# Charlotte Department of Transportation

## Memorandum

**Date:** April 30, 2008

**Subject:** Rezoning Petition 08-080: Located on the southwest corner of  
Providence Road West and Marvin Road

**SITE PLAN**

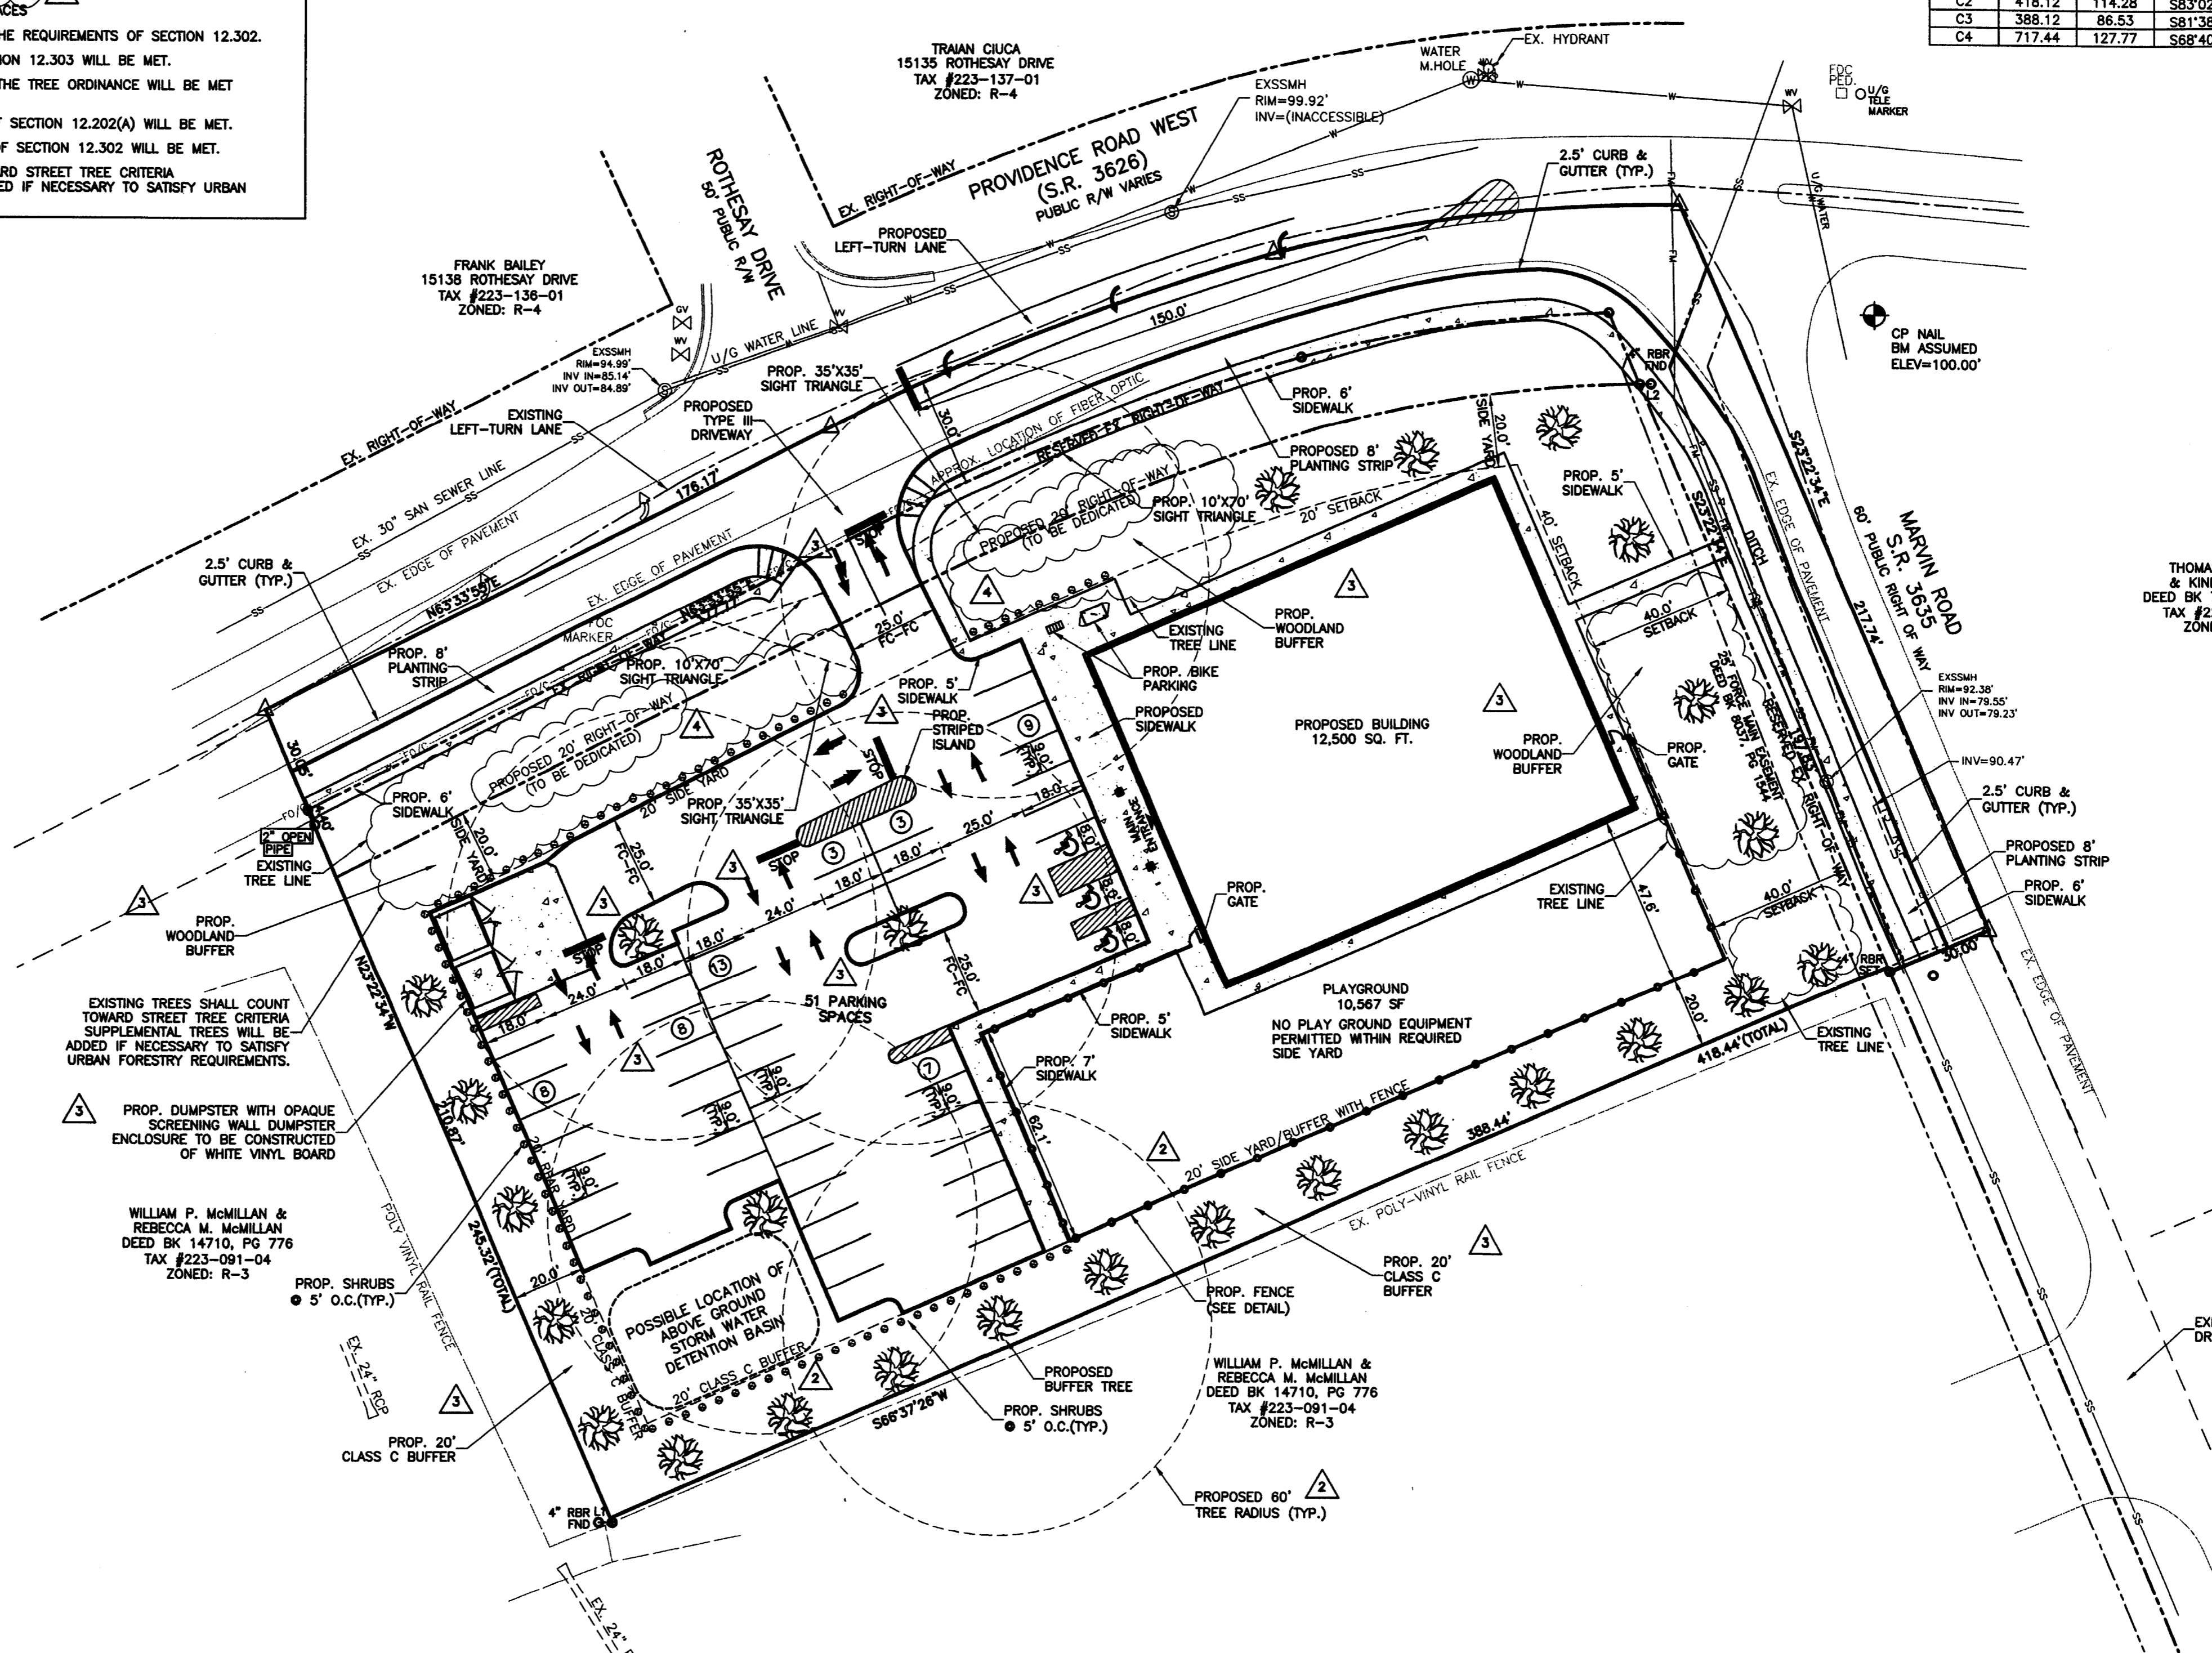
1. A left-turn lane needs to be striped on Providence Road West for the traffic using the proposed private driveway connection for this site. The engineering design and construction of the left-turn lane is the responsibility of the owner, and shall be performed by a professional engineer registered in the State of North Carolina who has roadway-design experience. CDOT will only approve the proposed private driveway connection provided that a left-turn lane is constructed on Providence Road West. We recommend the rezoning plan reflect the design of this required left-turn lane prior to submittal/approval of the public street/private driveway connection. This roadway improvement is required to meet the traffic demands of the proposed development. The left-turn lane should be designed with a minimum 150 feet of storage.

2. The developer must provide 8' planting strips and 6' sidewalks along both Providence Road West and Marvin Road.
3. The proposed Type III driveway to the site needs to align with the existing Rothesay Drive to avoid minor offsets wherever possible.
4. Adequate sight distance triangles must be reserved at the proposed driveway connection. Two 35-foot x 35-foot sight triangles are required for the street connection to meet CDOT sight distance requirements. All proposed trees, berms, walls, fences, and/or identification signs must not interfere with sight distance at the street connection. Such items should be identified on the site plan.

1. Standard curb and gutter is required along Providence Road West and Marvin Road street frontages. The placement of this curb and gutter will be determined in the building permit/driveway permit review.
2. The developer needs to provide 5' minimum internal sidewalks connecting the primary building entrance with both Providence Road West and Marvin Road.

Providence Road West is a major thoroughfare requiring a minimum of 100 feet of right-of-way. The developer/petitioner should convey right-of-way in fee simple title to meet this requirement, measuring 50 feet from the centerline of the roadway.

Adequate sight triangles must be reserved at the existing/proposed street entrance(s). Two 35' x 35' sight triangles are required for the entrance(s) to meet requirements. All proposed trees, berms, walls, fences, and/or identification signs must not interfere with sight distance at the entrance(s). Such items should be identified on the site plan.

To facilitate building permit/driveway permit review and approval, the site plan must be revised to include the following:

- Dimension width of the proposed driveway.
- Indicate the locations and widths of all adjacent and opposing driveways.
- Indicate typical parking module dimensions.
- Include a parking summary with figures for the numbers of parking spaces required and provided.
